CONSULTEE RESPONSE (Council's arboriculturist)

Reference: M/16/22/PL

Proposal: Laying out of an 18 hole 72 par golf course, a 9 hole golf course, practice greens and a driving range including a buggy compound; the formation of a new access onto the A259; construction of a club house with associated golf club facilities; the construction of a maintenance building and external area of hardstanding; the laying of parking, new roads and paths; new landscape planting; surface water drainage basins and water storage reservoirs; and other earth works and infrastructure. This application also lies within the parishes of Climping and Yapton, is a Departure from the Development Plan and affects a Public Right of Way. This application is subject to an Environmental Statement.

Location: Land South of Grevatts Lane/A259, Climping

drawing title
TREE PROTECTION PLAN

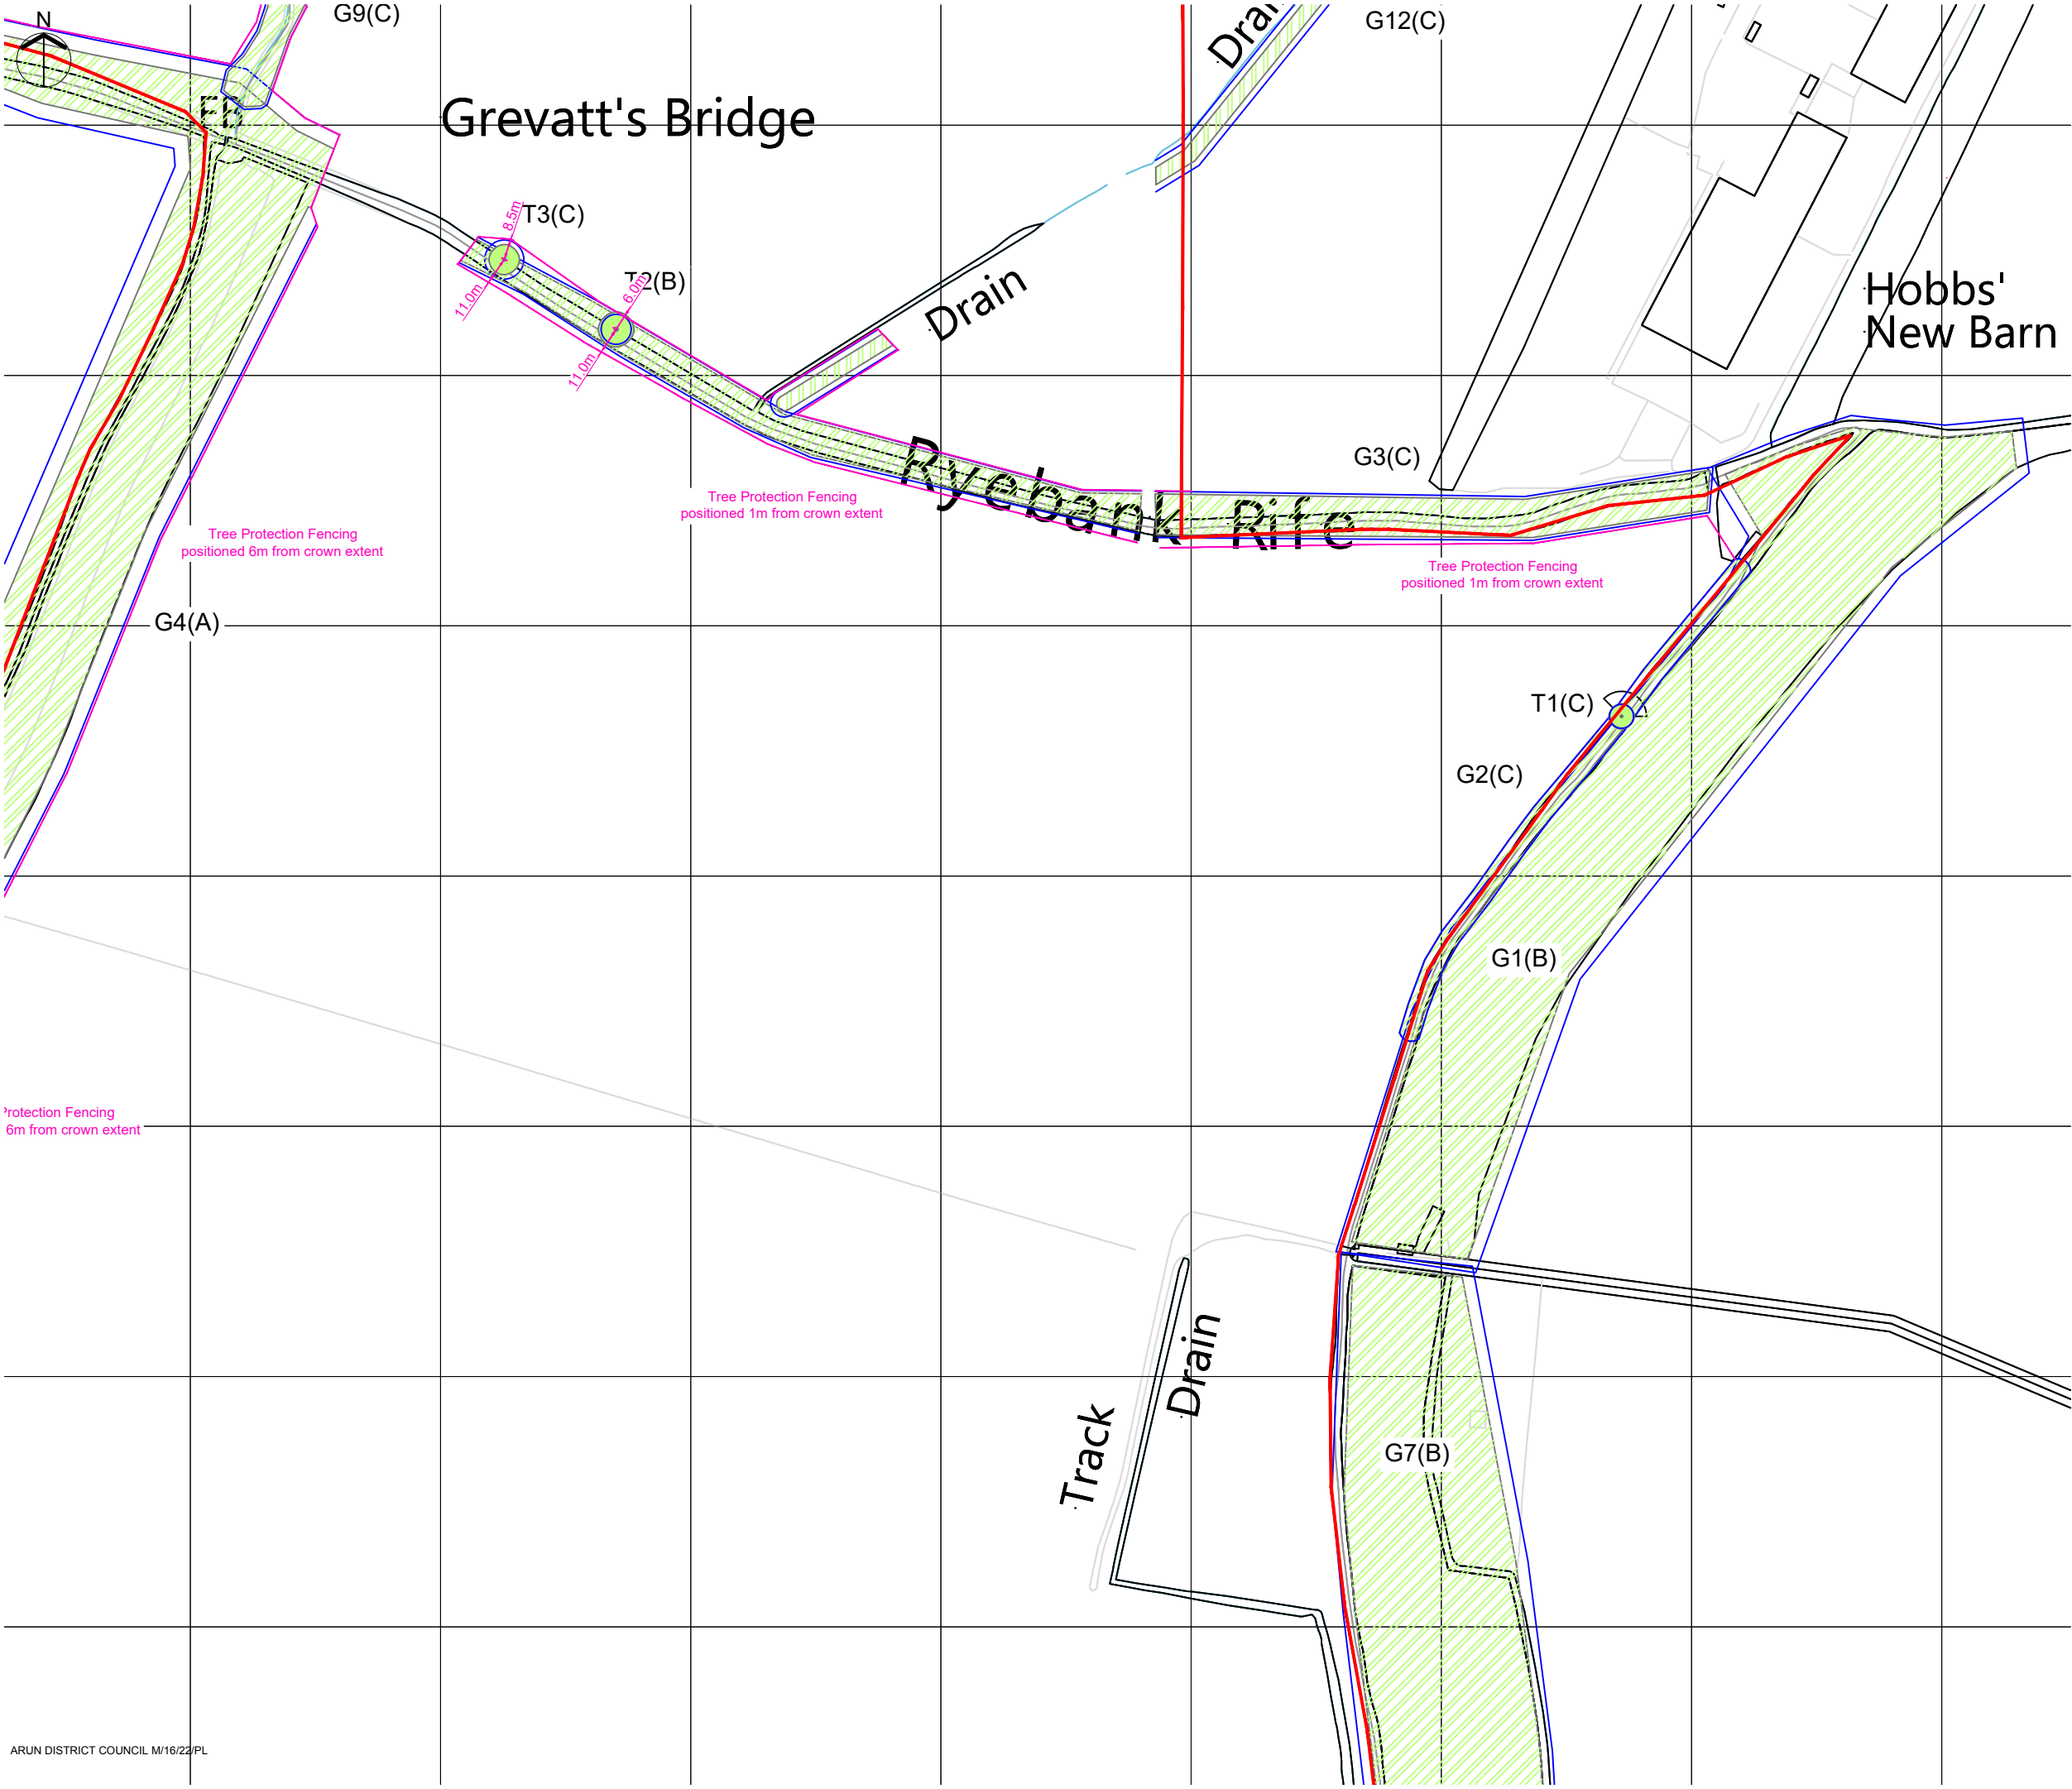
No Tree Protection Plan or Arboricultural Method Statement has been provided. Ideally this level of information should be provided up front in support of a detailed layout, for an application at this stage.

If the root protection area (RPA) of any tree which is proposed for retention overlaps the development, then BS5837:2012 requires that the Detailed Planning Application is accompanied by an Arboricultural Method Statement (AMS) and most importantly a Tree Protection Plan – to both describe and illustrate the mitigation measures which are to be employed to ensure that the trees survive without detriment to their vigour and vitality and are given adequate protection both above and below ground.

If you are minded to approve this application it will need to be supported by an **Arboricultural Method Statement** and associated **Tree Protection Plan(s)** defining which trees are to be retained, which are to be removed and how they would propose to protect the retained trees and if necessary mitigate any adverse impact on the root systems of these trees.
